TECHNICAL REVIEW - SURFACE WATER ASSESSMENT (SSD-5765)

Project:	N1221_001 Bowdens Silver Surface Water Review	Date:	27 July 2020
To:	Lue Action Group	From:	Susan Shield
ATT:	Phil English	CC:	Jack White
Subject:	Surface Water Review – Technical Comments

Figure 7 –WRE cells layout.

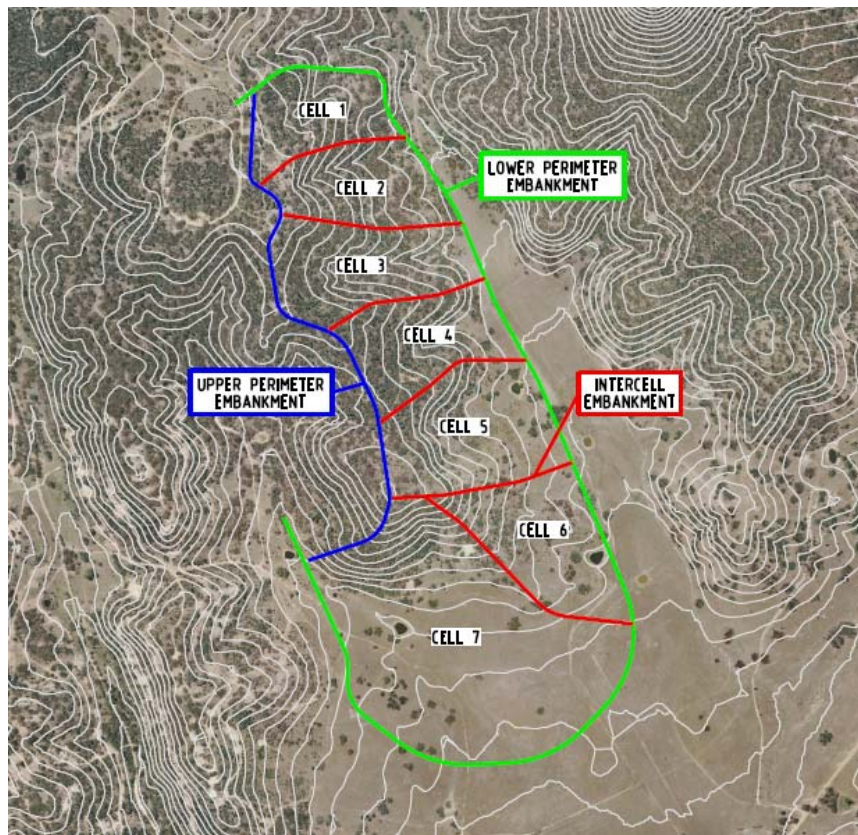
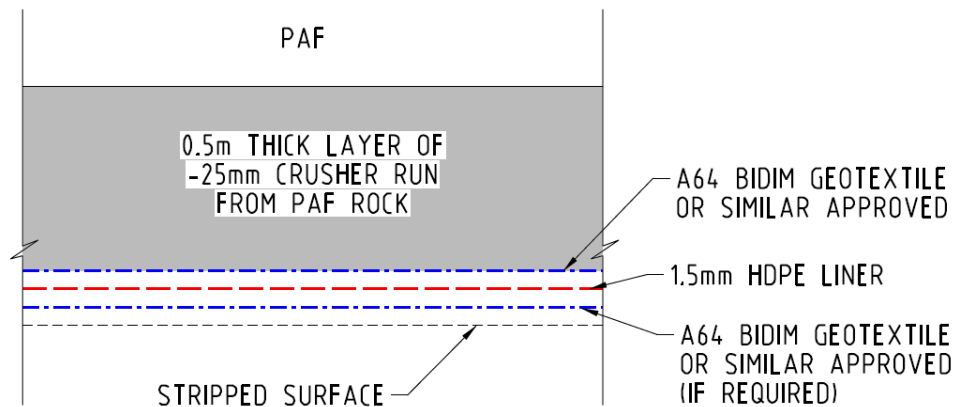
There is no clearly defined trigger to use containment dams rather than sediment dams for Waste Rock Emplacement (WRE). The assessment should commit to initially use containment dams for the WRE and only use sediment dams if it can be demonstrated to the regulators that the water is of suitable quality.

Section	Aspect
Section 4.4.1.2 NAF Waste Rock	Geochem NAF water quality exceeds creek 80th percentile and ANZECC guidelines. How is this to be managed? Where is Corkery review Section 4.4.1.2 (page 6-56) – on what basis was this made?
Section 4.4.2.2 PAF Waste Rock	How is PAF to be managed during and post closure? How will the leachate dam and the leachate it receives be managed post closure?
